Application no: 20/03353/OUT

Location: Land West of Cotefield Business Park Oxford Road Bodicote

Following your letter dated 7th of January 2020, we respond to your queries below.

Permeable Car Park External

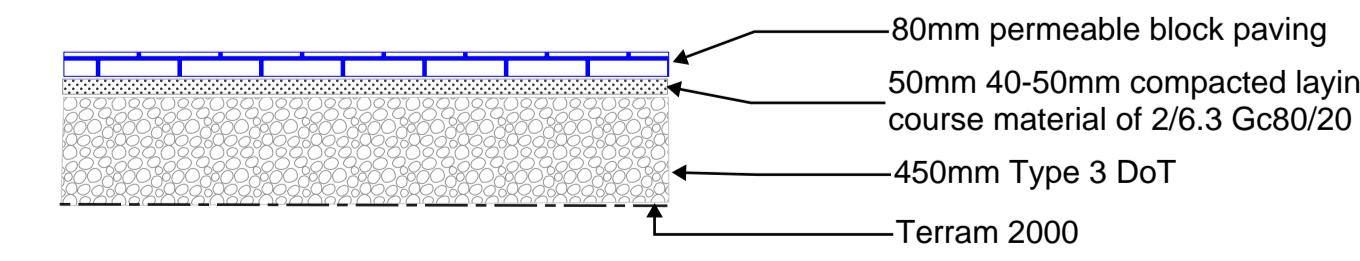
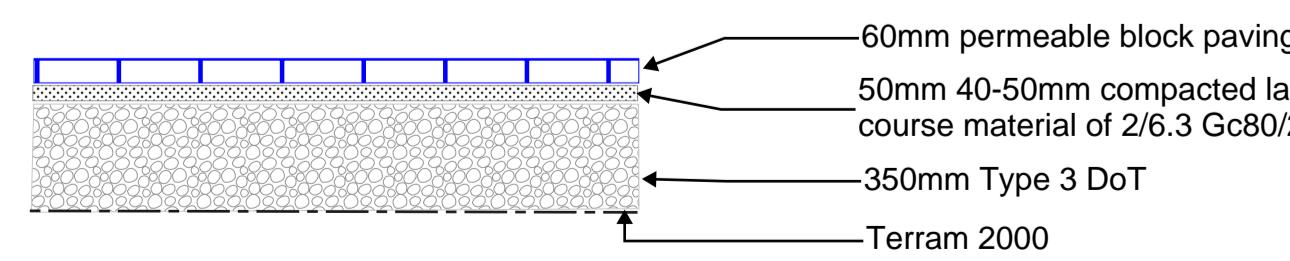
Query 1: The application must supply more details on the proposal. As the site lies within Groundwater Vulnerability Zone and includes parking spaces, water quality assessment must be carried out. The water quality assessment must be in accordance with Section 4 and Section 26 of SuDS Manual. Proposed development must meet local standards, L19, "At least one surface feature should be deployed within the drainage system for water quality purposes, or more features for runoff which may contain higher levels of pollutants in accordance with the CIRIA SuDS Manual C753. Only if surface features are demonstrated as not viable, then approved proprietary engineered pollution control features such as vortex separators, serviceable/ replaceable filter screens, or pollution interceptors may be used"

Response: The new surface water drainage proposals are shown on the drainage strategy drawings. The surface water from the roofs goes through the RWP and then goes to the surface water pipe network. These drains in turn discharge to the sub-base of the car park area via a water distribution chamber. All the flow is infiltrate into the ground using the sub-base of the car park area.

The permeable surface will remove the soils and provide a water treatment to the surface water. See below print screen of the treatment capacity of the permeable sub-base. We conclude that the proposed SuDS train provides a good treatment of surface water.

SURFACE WATER
DRAINAGE STRATEGY

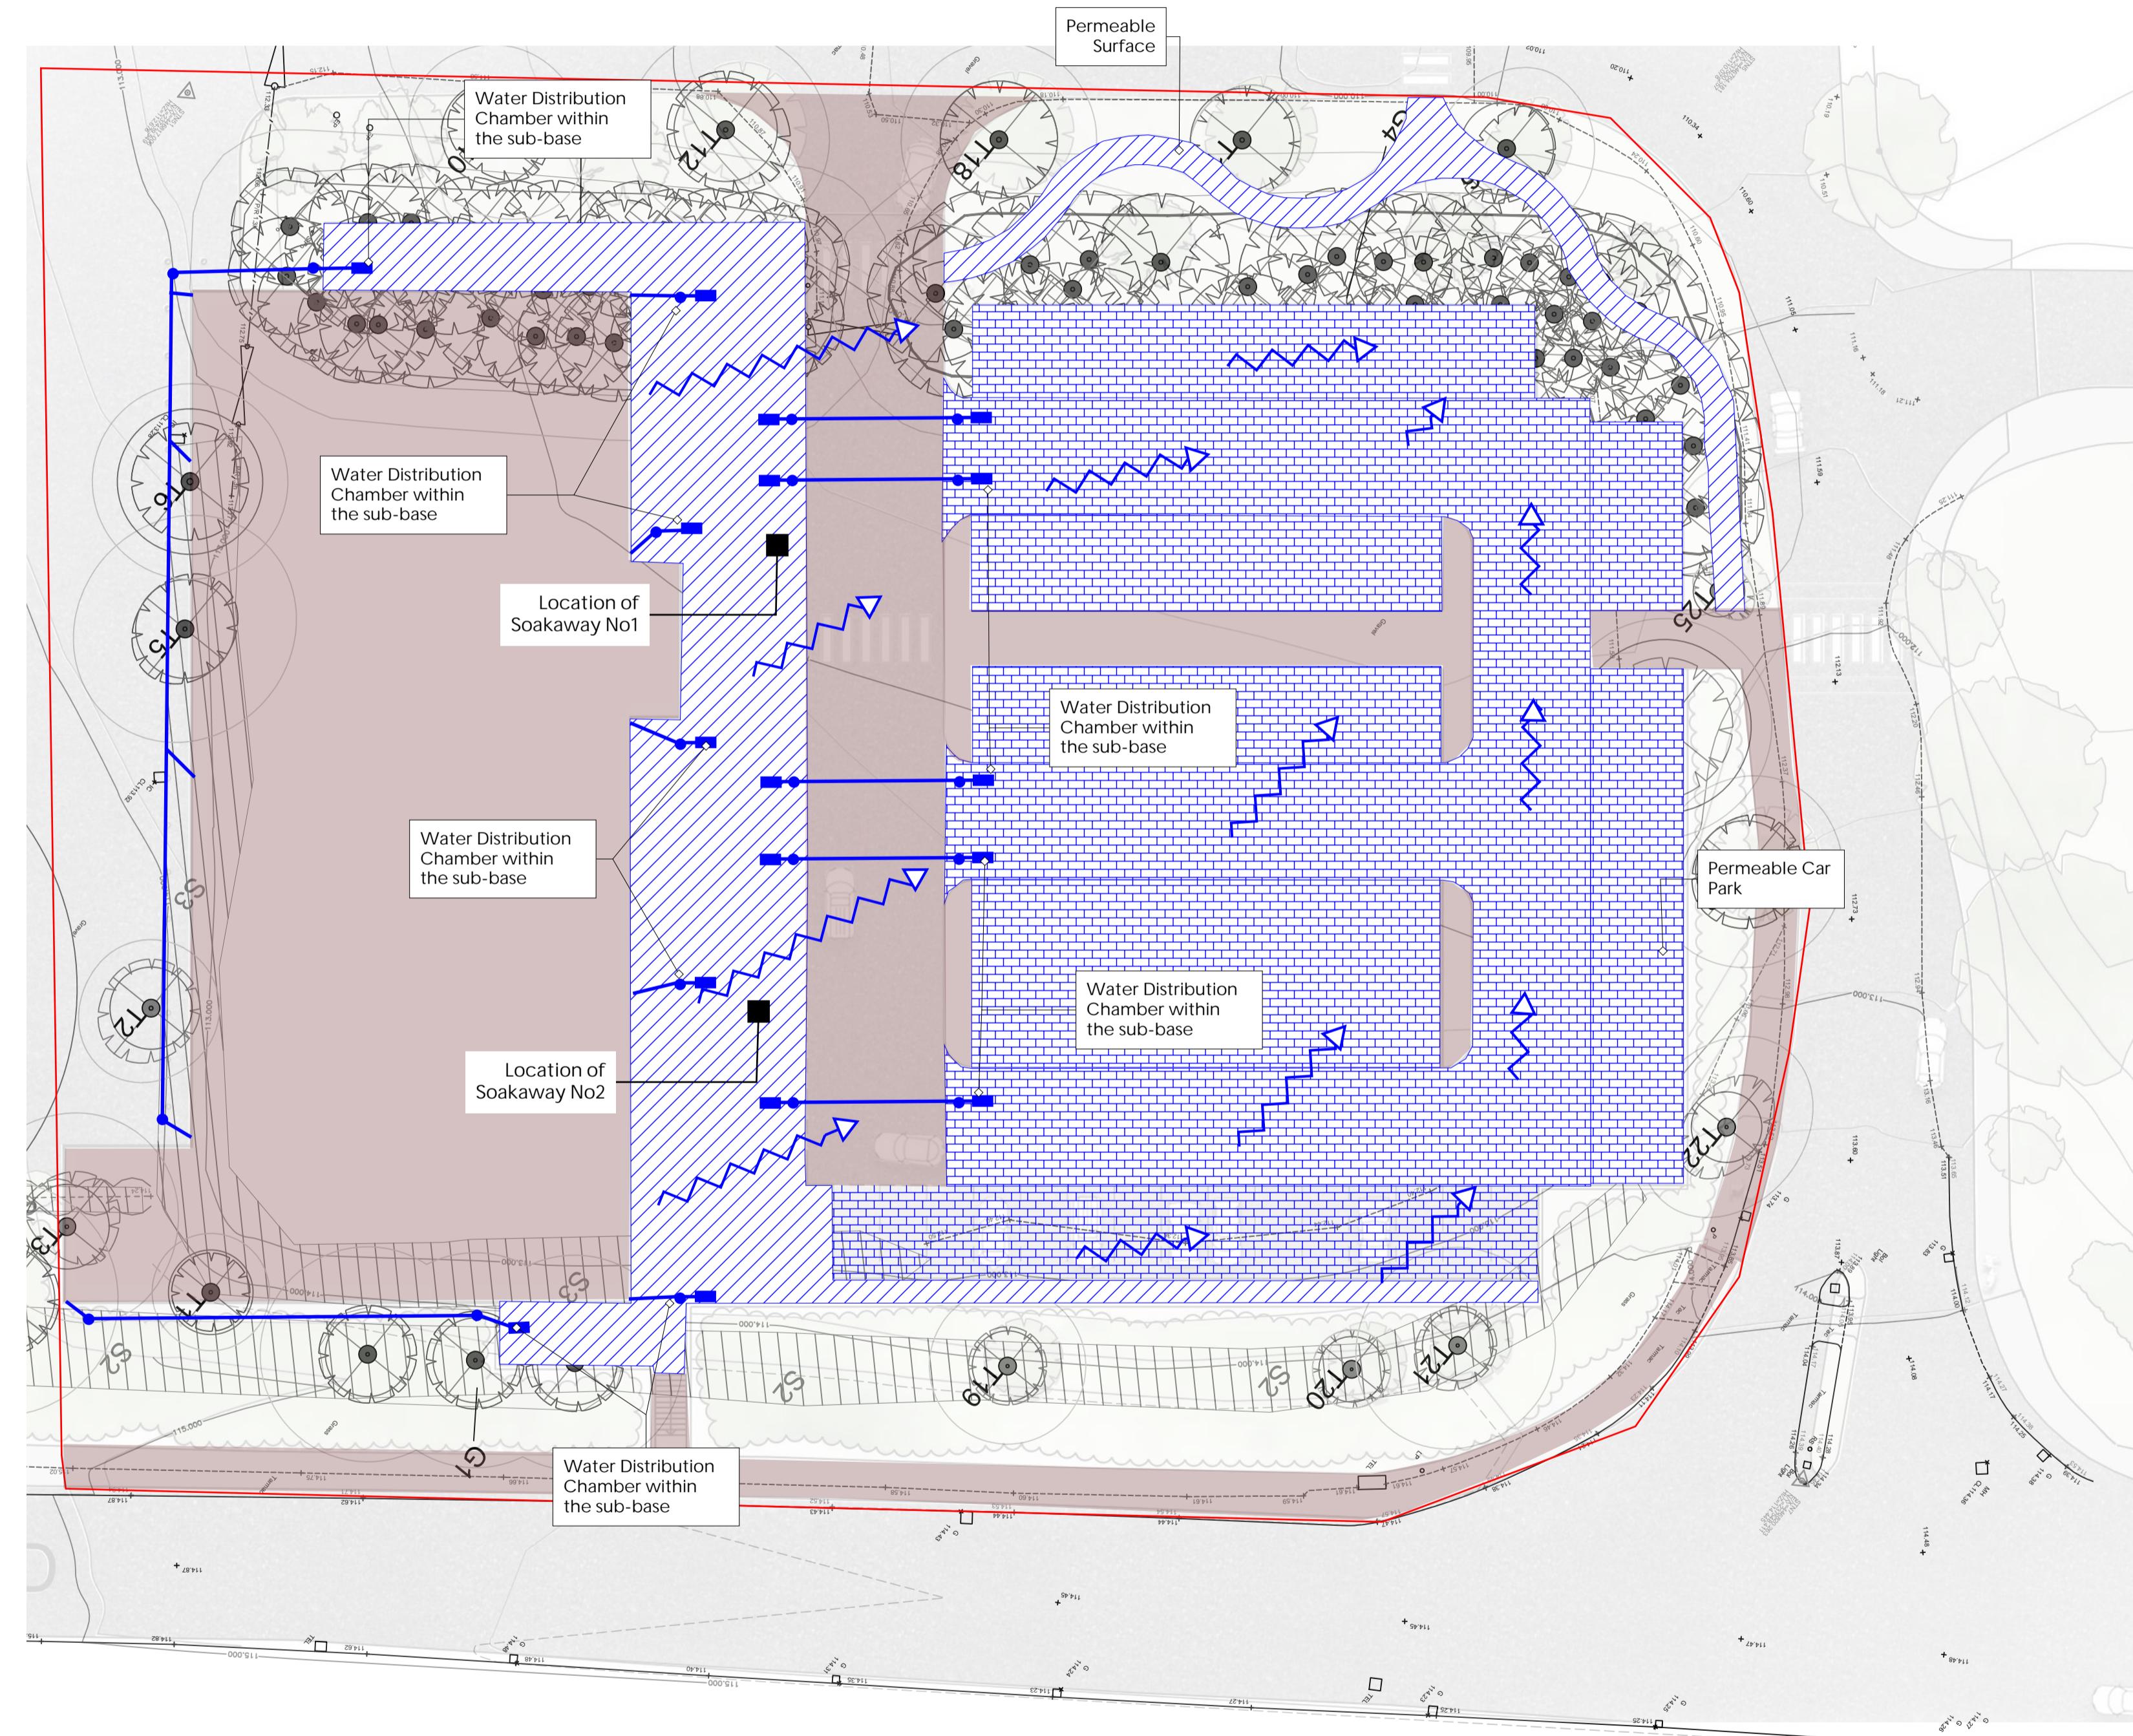
Query 2: The drawing provided needs to be clearer and more detailed. It needs to show the water quality treatment measures, where proposed infiltrations systems are and exact location of trial pits. Each item should be easy to identify and clearly stated in the drawing key.

Response: See enclosed updated drainage layout showing the location of the soakaways, the sub-base of the car park and the details of the drainage system.
